Project # 7036 81st Ave SE, Mercer Island 98040

Correction Notice #1

Date: 12/10/20

Review Type: Fire, Land Use, Building, Civil, and Trees

**1**  
A101 Lower Level  
SCALE: 1/4" = 1'-0"

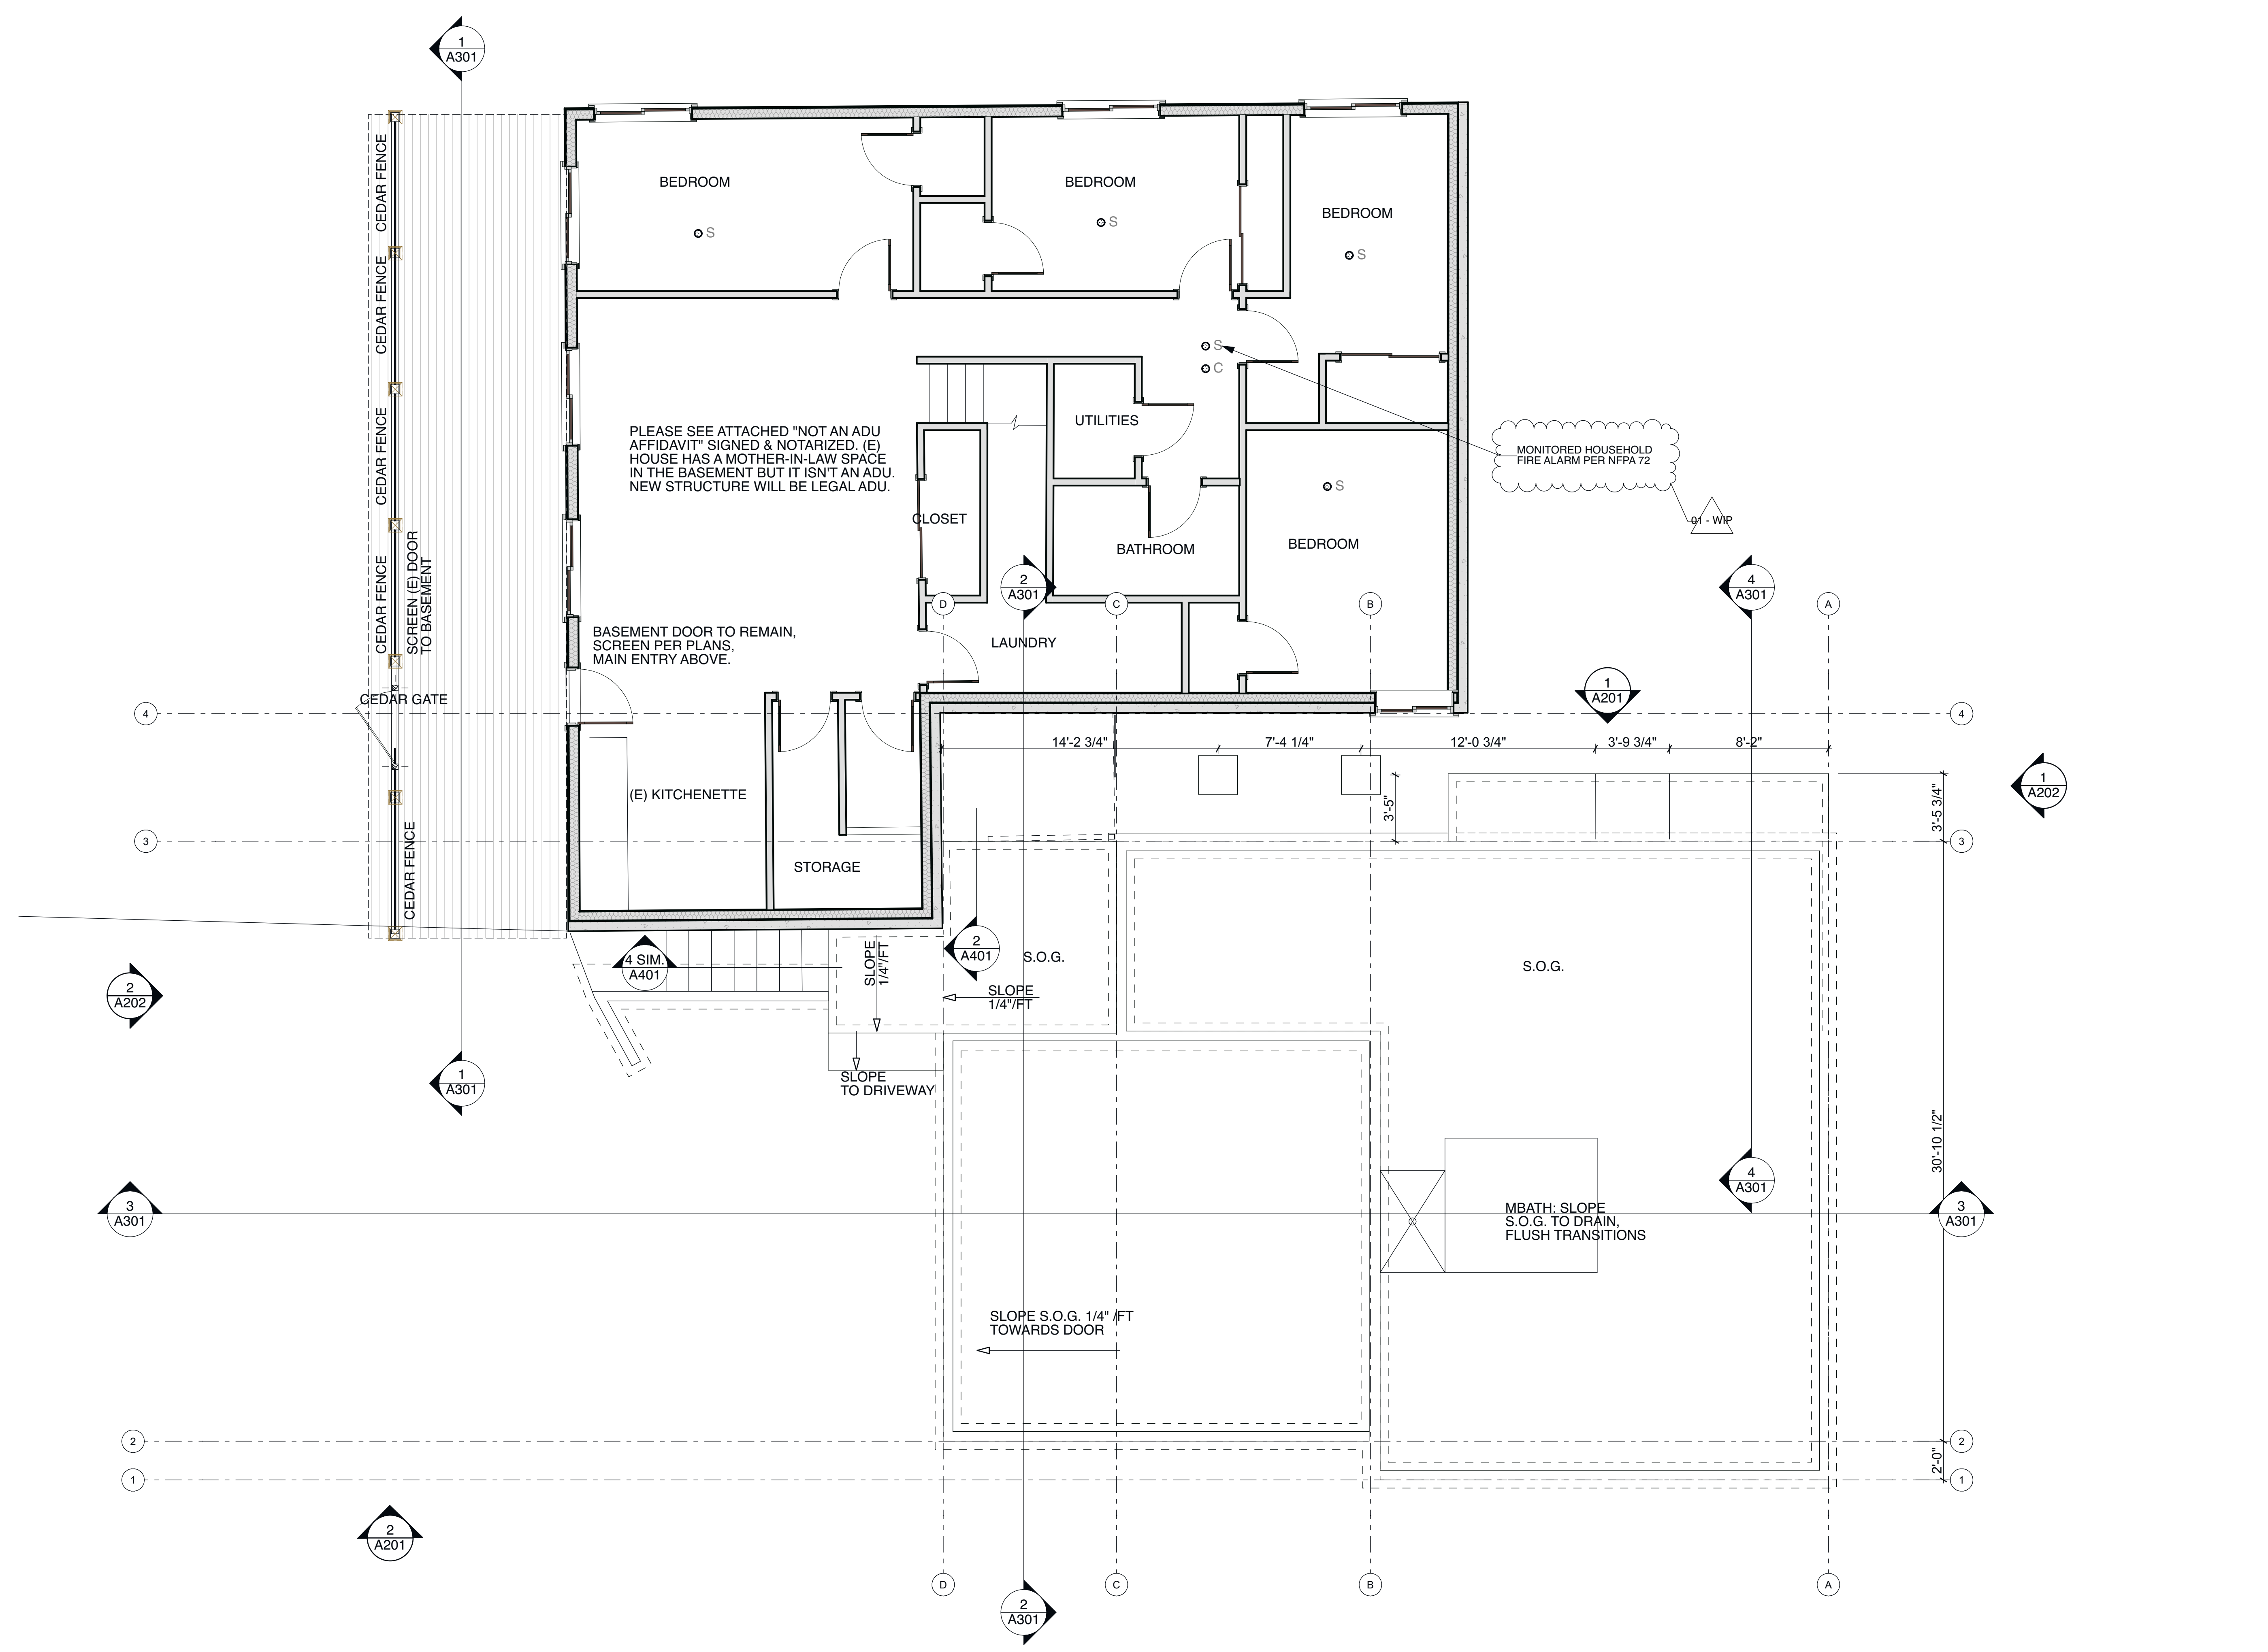
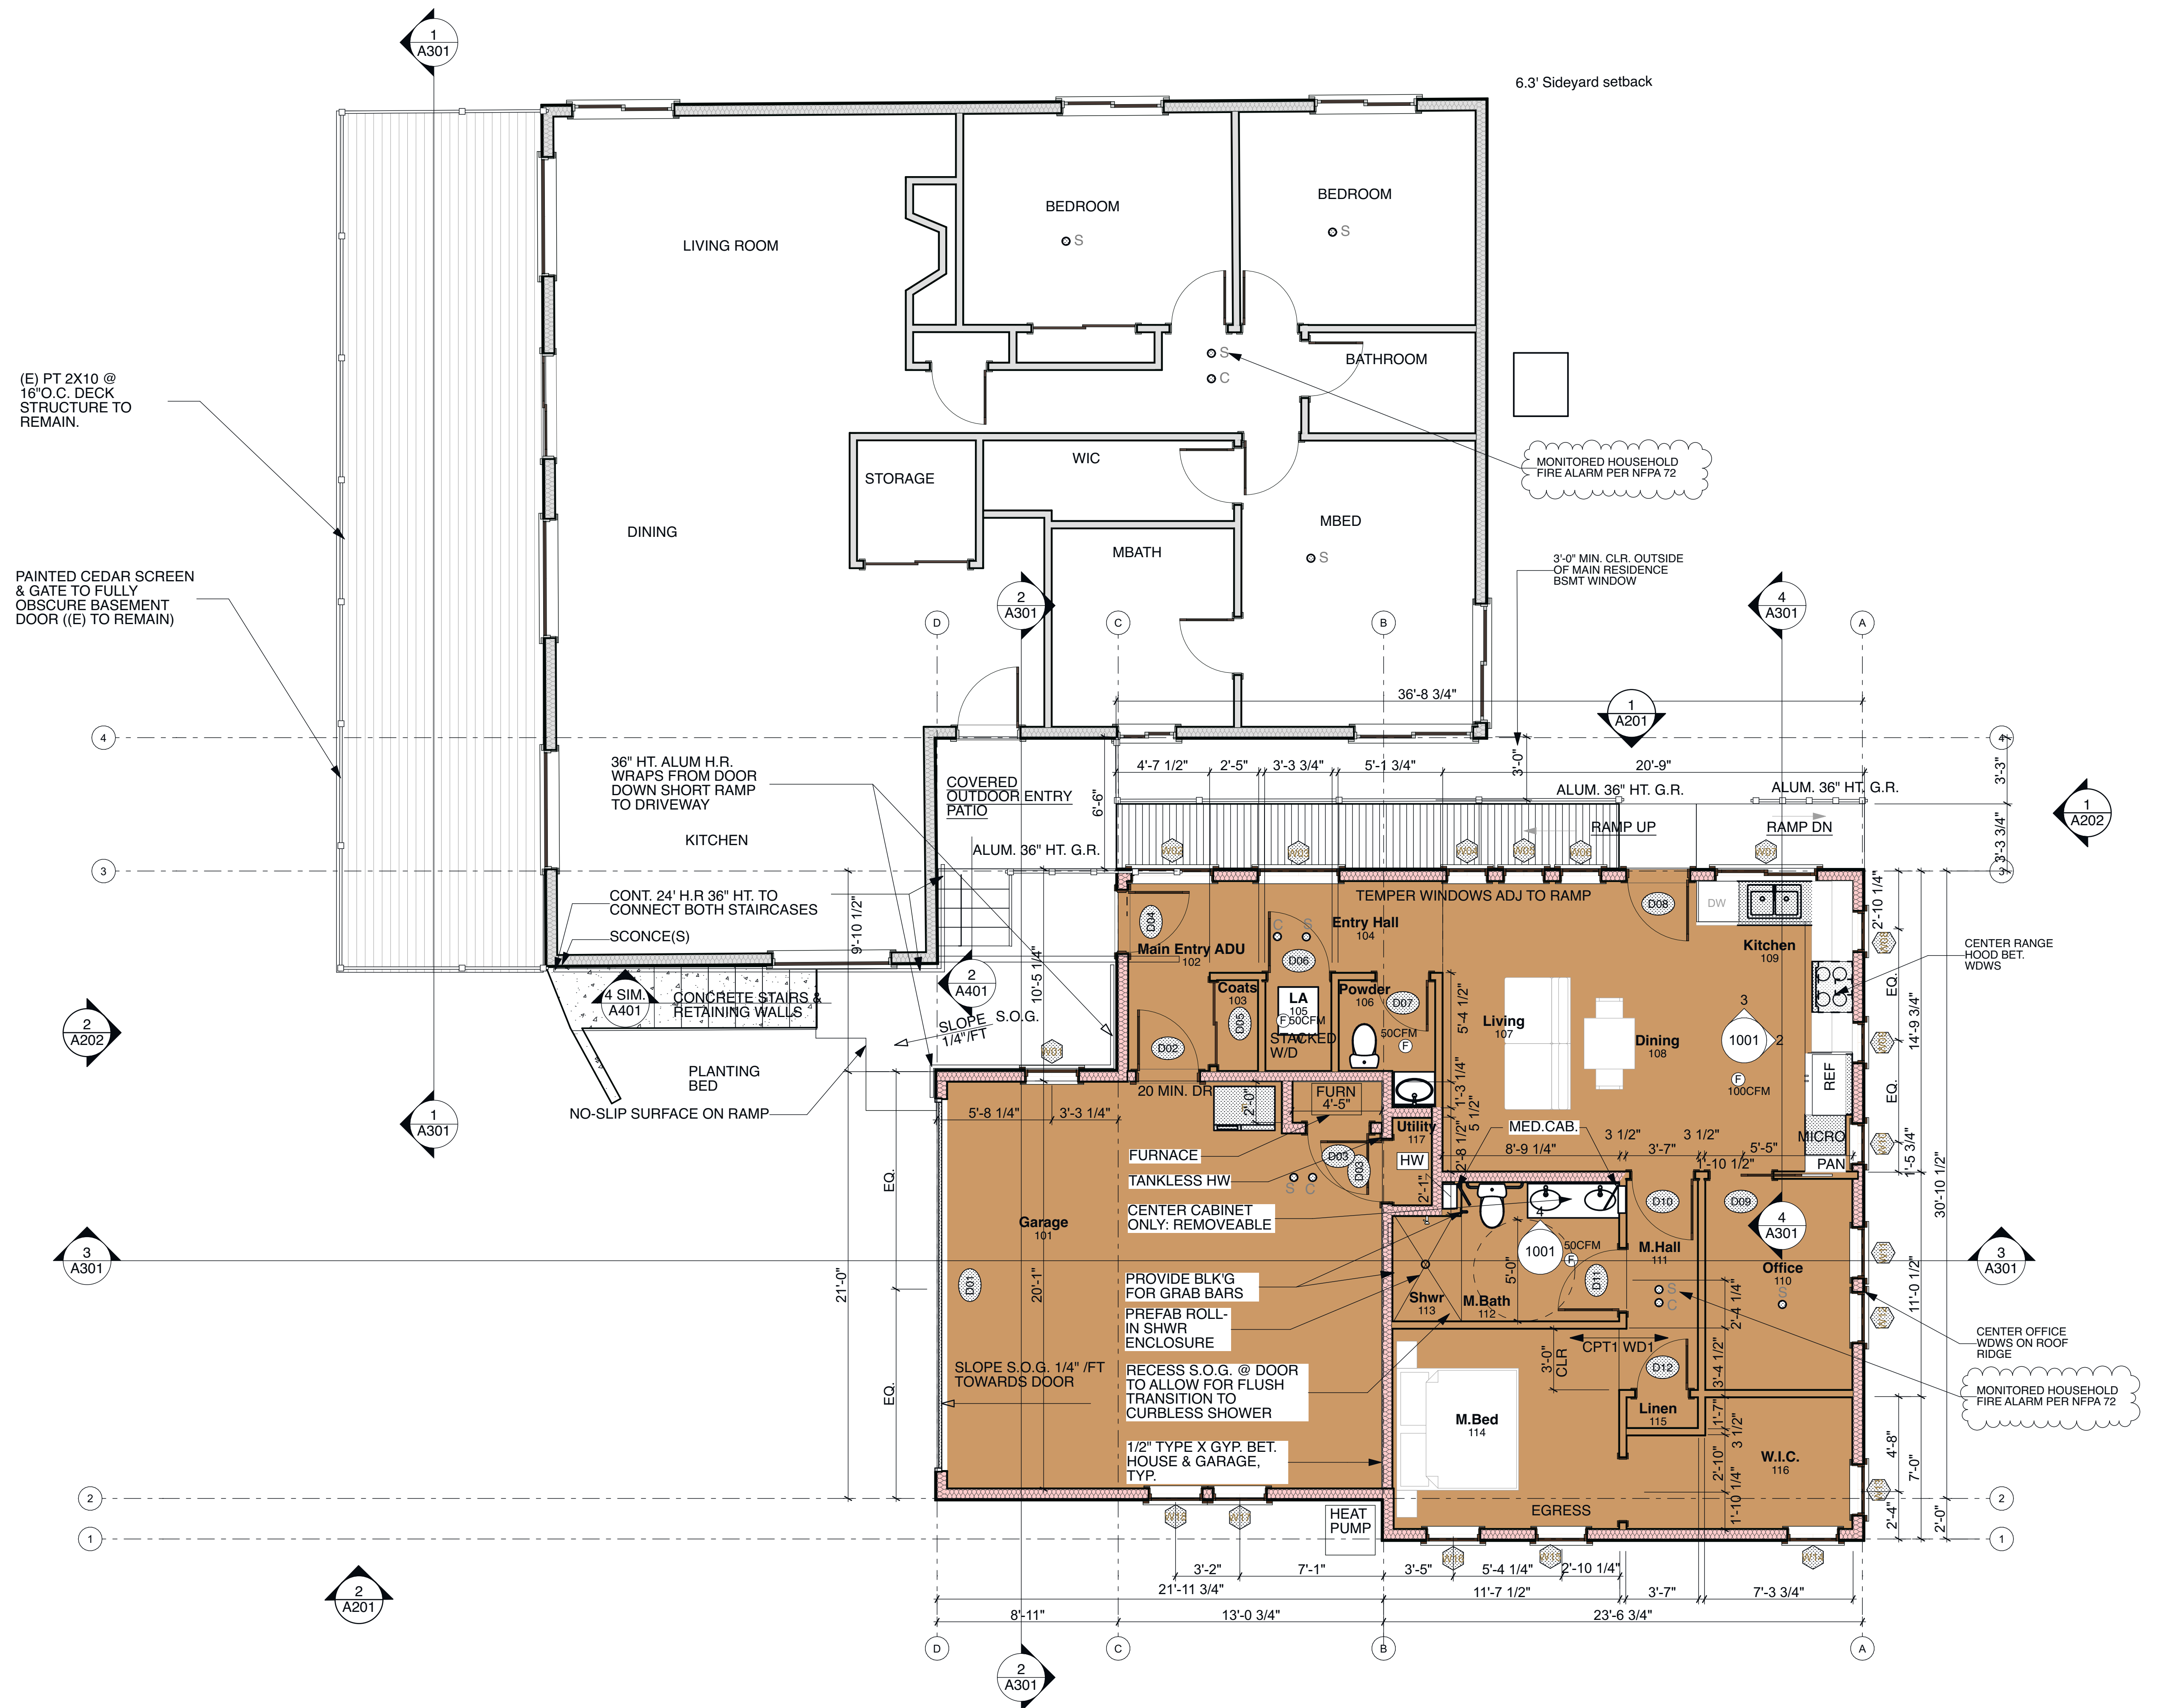
Monitored Household Fire Alarm per NFPA 72 required in both the main residence and the ADU

I let the owner and contractor know, made a note on A001 and on all floor plans containing smoke detectors, A101 & A102. I've also uploaded the required documents approved by the fire marshal.

**A201**

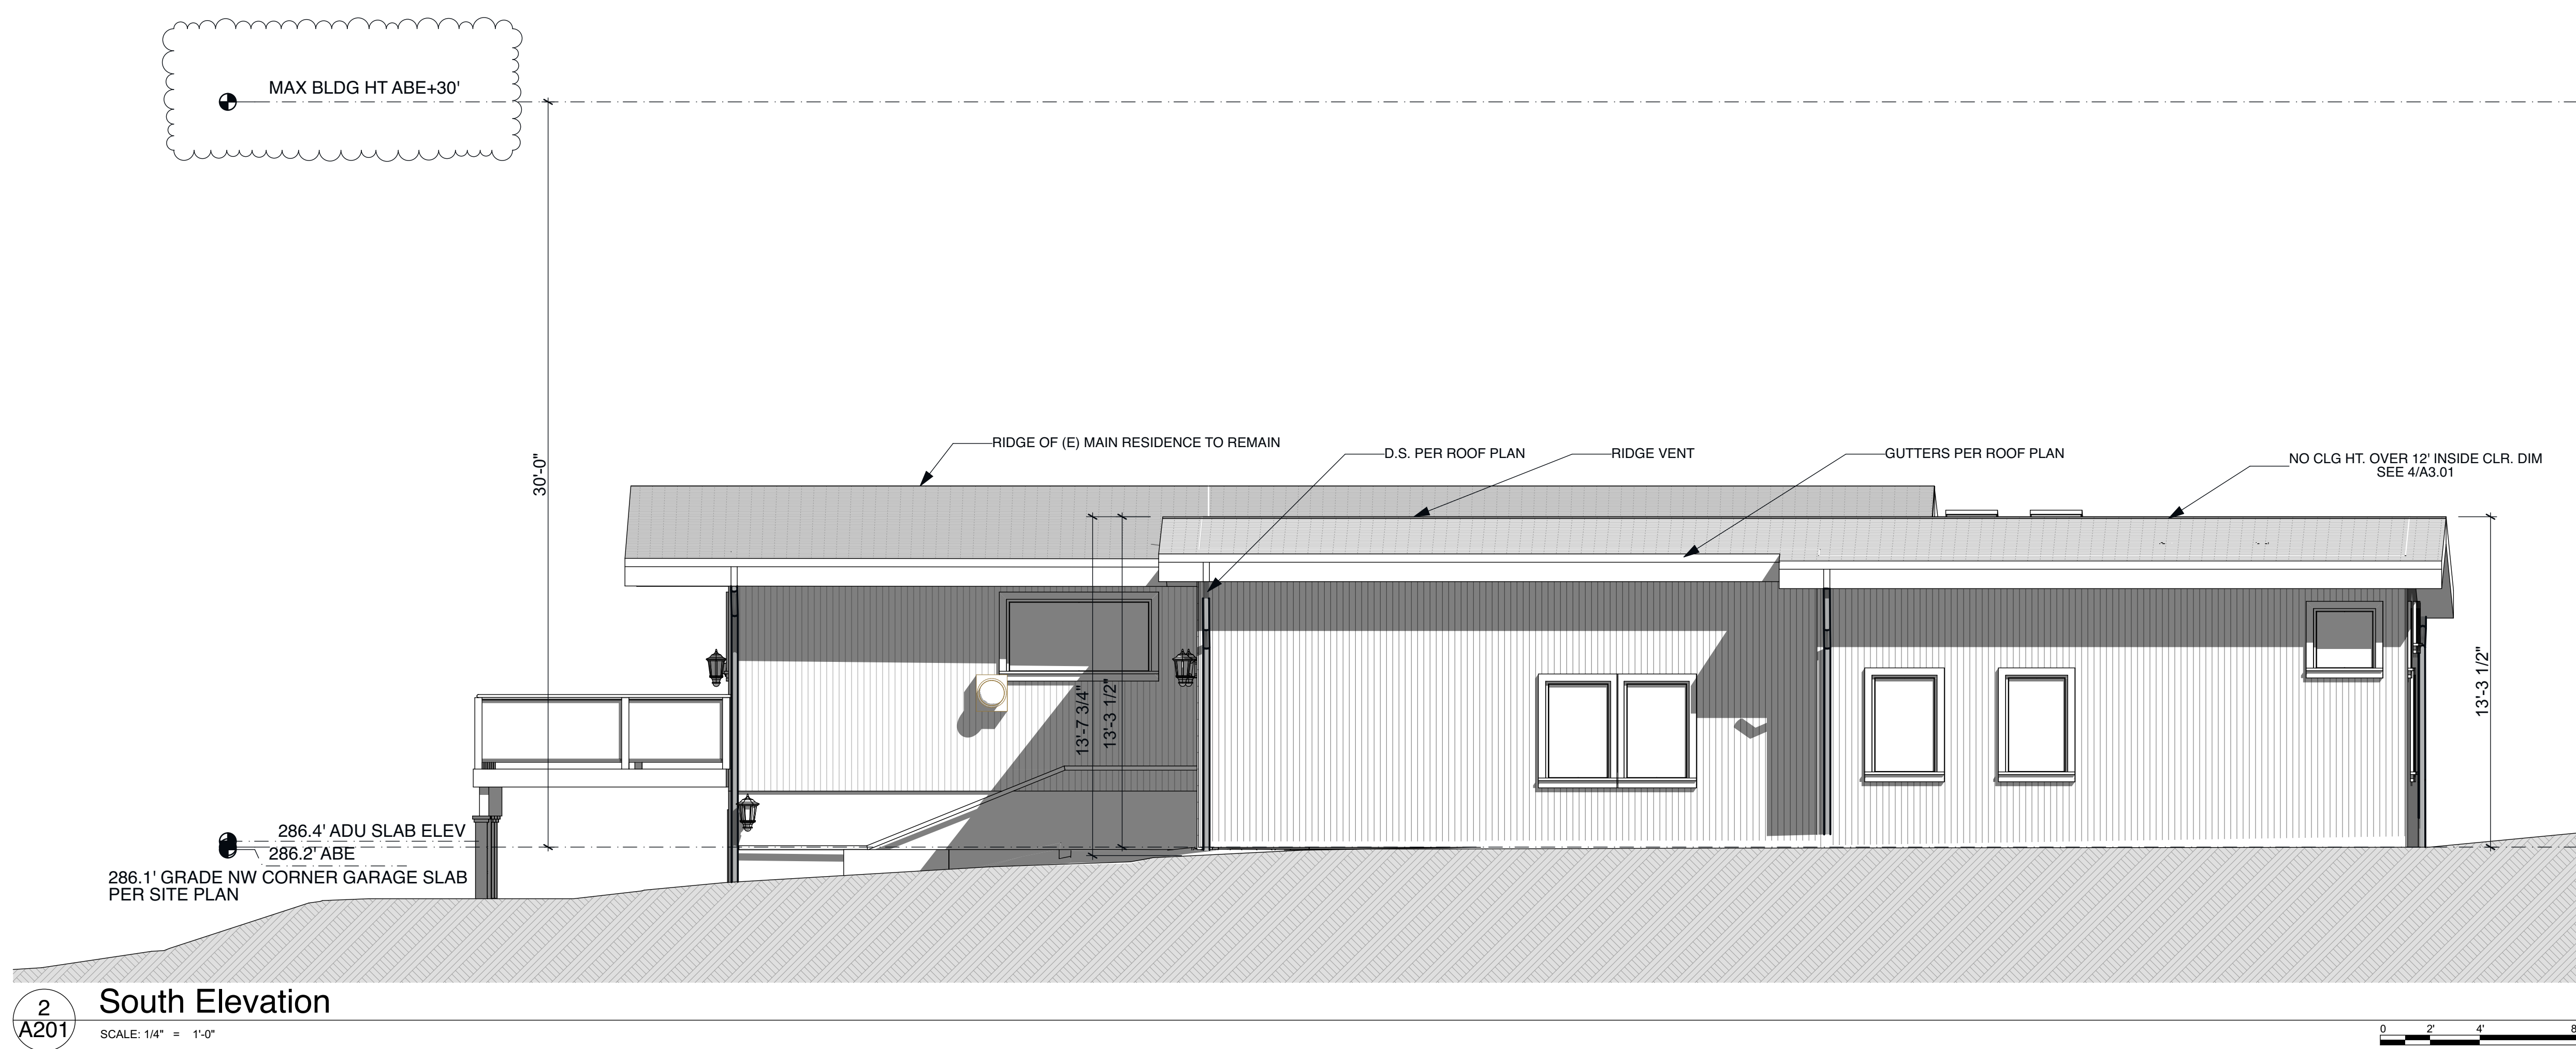
The maximum allowed building height is not 17' but 30" from ABE. Please revise the note on the elevation drawing

Please see the elevation showing the correct maximum building height on A201
